HORNSEA PROJECT THREE OFFSHORE WIND FARM

Planning Inspectorate Reference: EN010080

**NATURAL ENGLAND**  
**WRITTEN SUBMISSION FOR DEADLINE 3 – Issue Specific Hearing 2**  
**Part 2: Benthic**

**Annex 2.2B Natural England and JNCC responses to Applicant's responses to Natural England WR in relation to Benthic Ecology**

Figure 2.1: Seabed sediment and sandwave distribution within the Hornsea Three Offshore Cable Corridor Disposal Site.

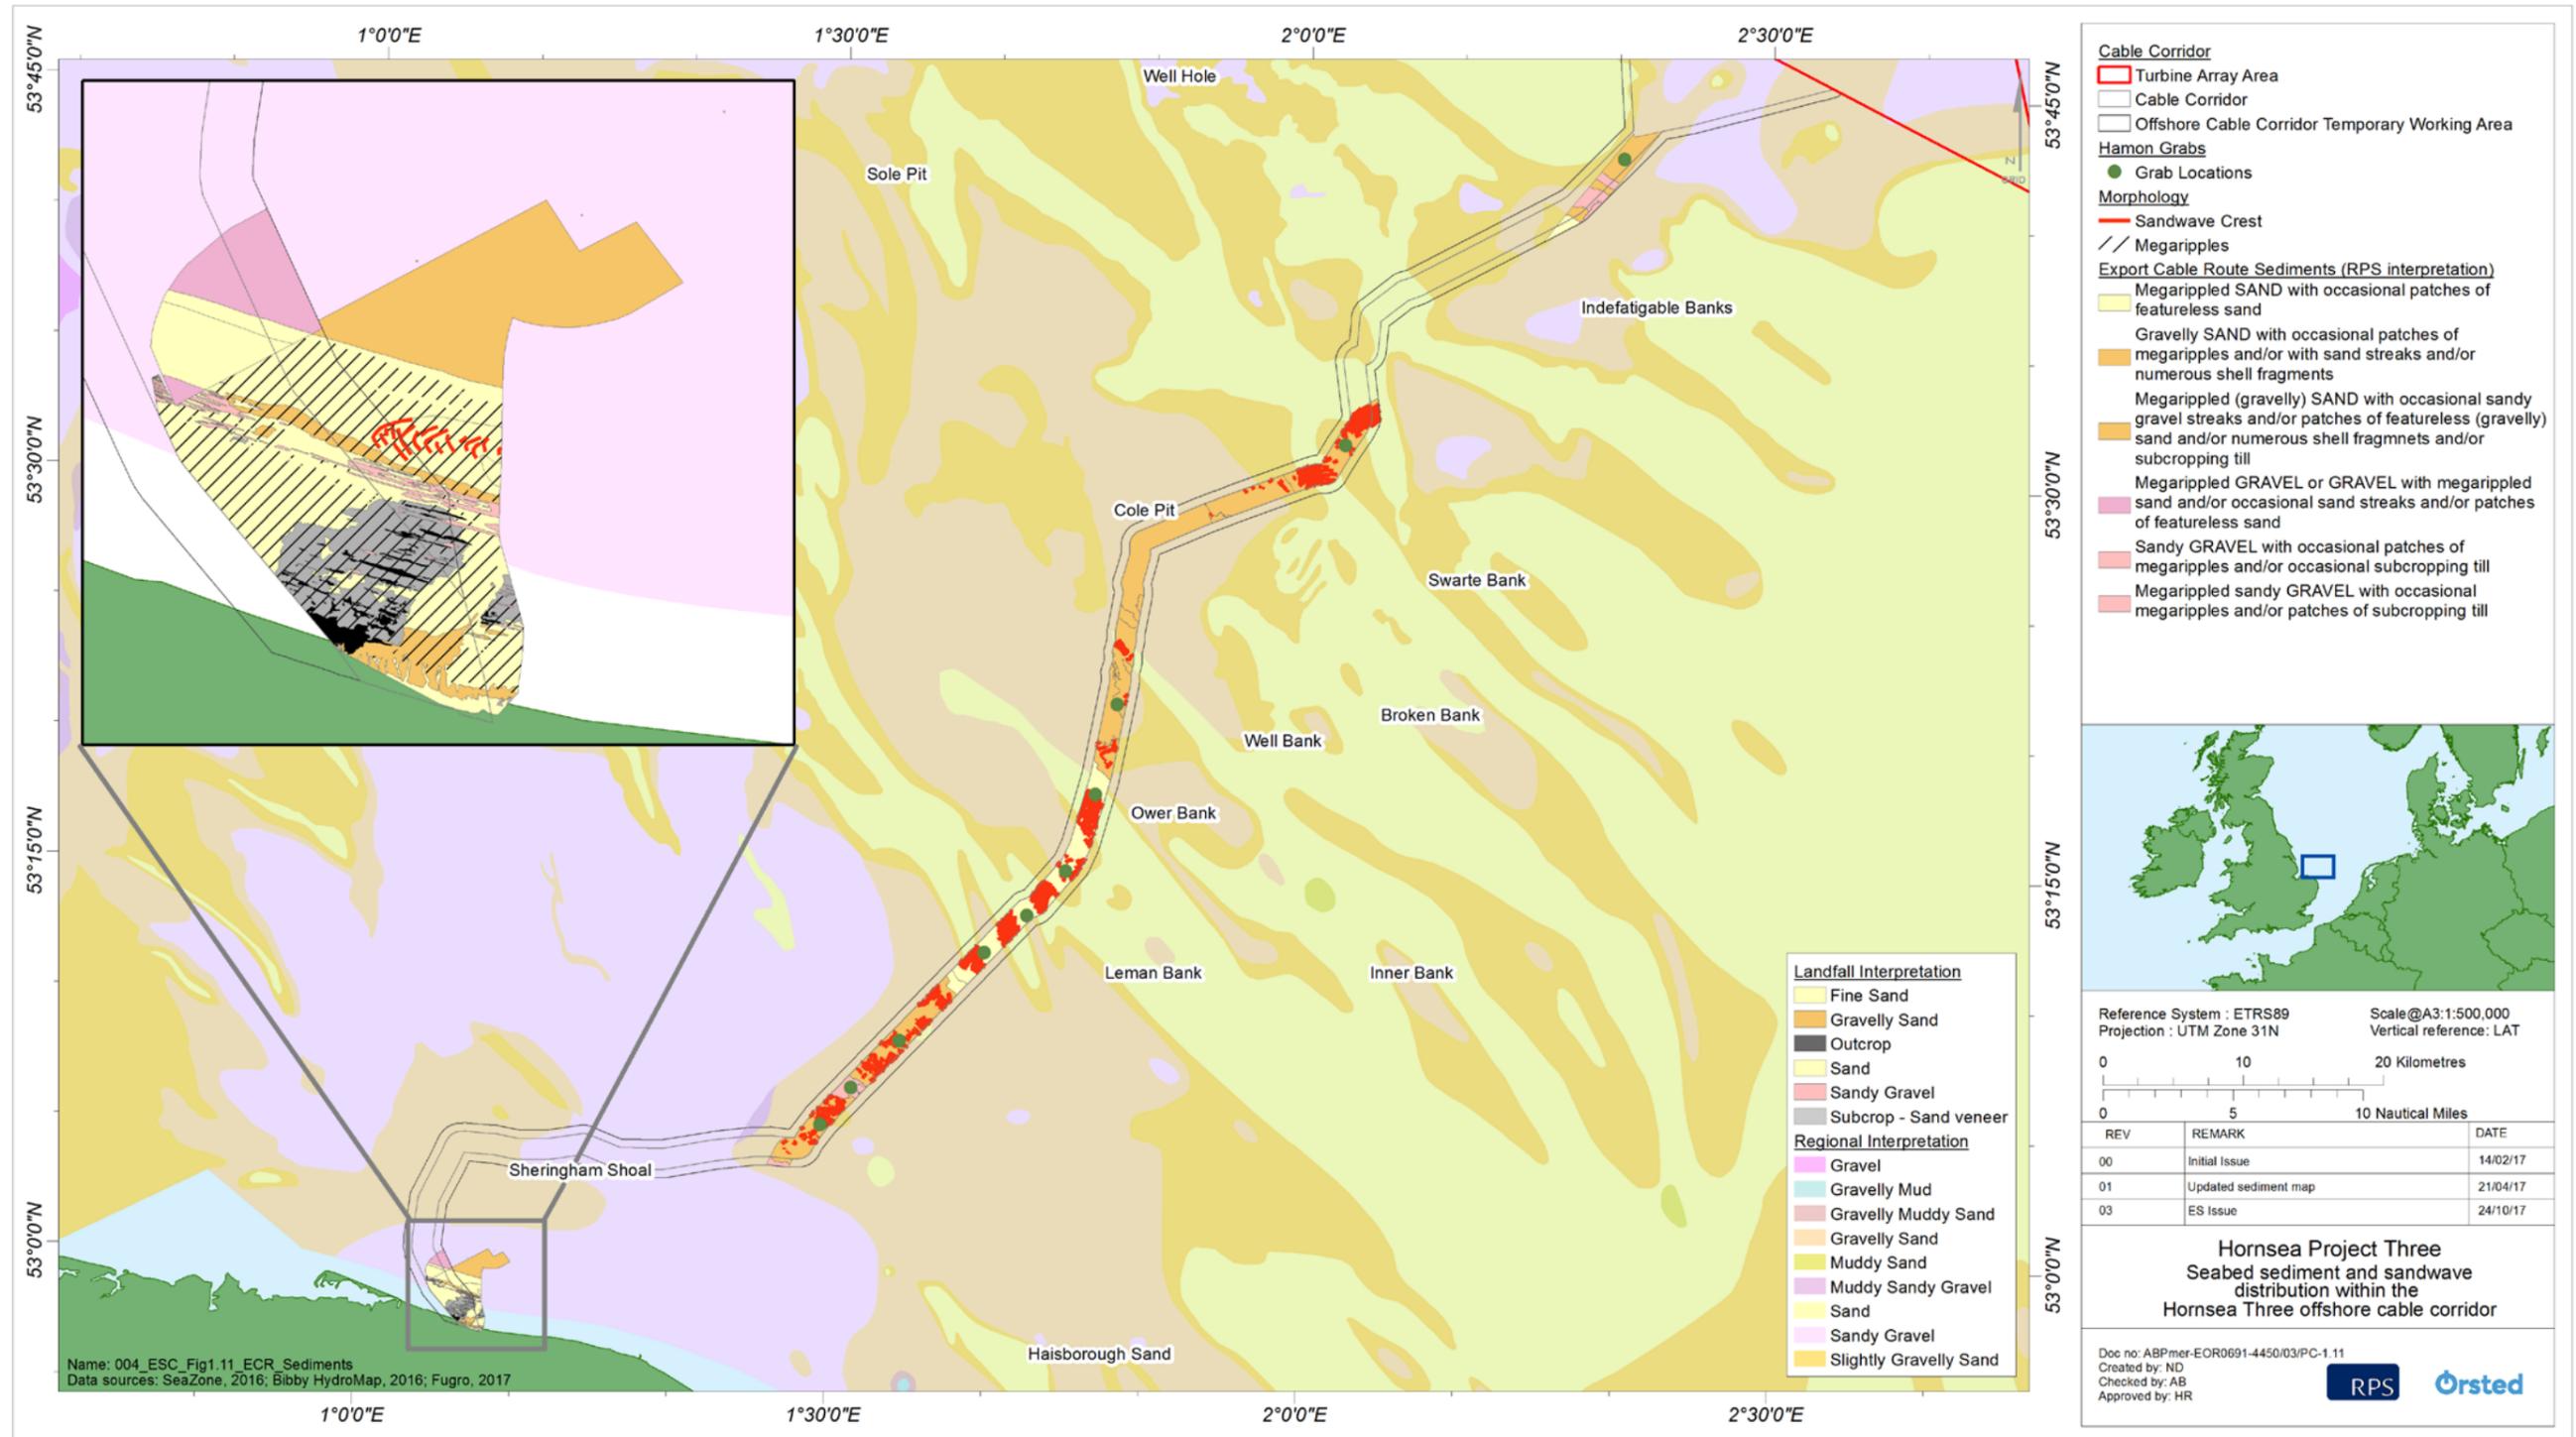
| 3 | <p>The Applicant refers the Ex.A to Figure 2.9 of Volume 2, Chapter 2: Benthic Ecology of the Environmental Statement (APP-062) which shows the potential future Annex I Sabellaria spinulosa reef within the Hornsea Three offshore cable corridor (i.e. the area highlighted in the Natural England Written Representation).</p>                |  |

| <p>during one previous survey, so is similarly not considered to represent an area of ‘established reef’. The latest data points mapped along the southern boundary of the offshore cable corridor, coinciding with potential future Annex I S. spinulosa reef Area D in Figure 2.9 of Volume 2, Chapter 2: Benthic Ecology of the Environmental Statement, is where reefs were also mapped during the original Saturn Reef survey in 2003 and the JNCC survey in 2013. This was identified as an area of higher confidence reef in Volume 2, Chapter 2: Benthic Ecology of the Environmental Statement. The Applicant acknowledges that this is an area with the greatest potential for S. spinulosa reef to be present prior to construction but would also note that Area D lies within the offshore cable corridor working area and is therefore out with the area of potential direct impact from cable installation. While the JNCC data also show additional records in the vicinity of Areas A and B, which do coincide with the Hornsea Three offshore cable corridor, the assessment presented in Table 2.21 of Volume 2, Chapter 2: Benthic Ecology demonstrates that there is sufficient space in the remaining offshore cable corridor to allow for micrositing around these features.</p> | <p>The latest version of the UK reef layer (v8) is an updated representation of our scientific evidence and opinion on extent and distribution that ensures parity between fisheries management layers and habitat mapping layers.</p> <p>We <b>agree</b> with the applicant that survey data show the ephemerality of <i>Sabellaria</i> presence within the Saturn Reef region. Because of this, we continue to consider that precaution is essential when managing this Annex I feature offshore, and disagree with the Applicant’s use of their Figure 2.9 of Volume 2, Chapter 2: Benthic Ecology of the Environmental Statement as a baseline for <i>Sabellaria</i> presence.</p> <p>We <b>disagree</b> that the Applicant’s assessment presented in Table 2.21 of Volume 2, Chapter 2: Benthic Ecology of the Environmental Statement demonstrates that there is sufficient space in the remaining offshore cable corridor to allow for micrositing around these features, and we consider that there is a significant risk of further impairment of the conservation objectives if the operations occur.</p> <p><b>Reef layers</b></p> <p><i>Availability of evidence</i></p> <p>As requested at the offshore ecology hearing, we will provide publicly available material depicting <i>Sabellaria</i> data and metadata within NNSSR for <b>Deadline 4</b>. This has previously been provided several times in graphic format to the Applicant throughout the consenting process.</p> <p><i>Extent polylines</i></p> <p>We would also like to provide further information as to the process undertaken to consider reef extent in the areas questioned by the Applicant, which we believe to be those enclosed in the red box below:</p> |

| 4 | <p>Where the new JNCC data points overlap with the Areas E-G, reef has only been confirmed at these locations</p>   | <p>Please see (2) above concerning the Applicant’s confusion over understanding established reef.</p>  |
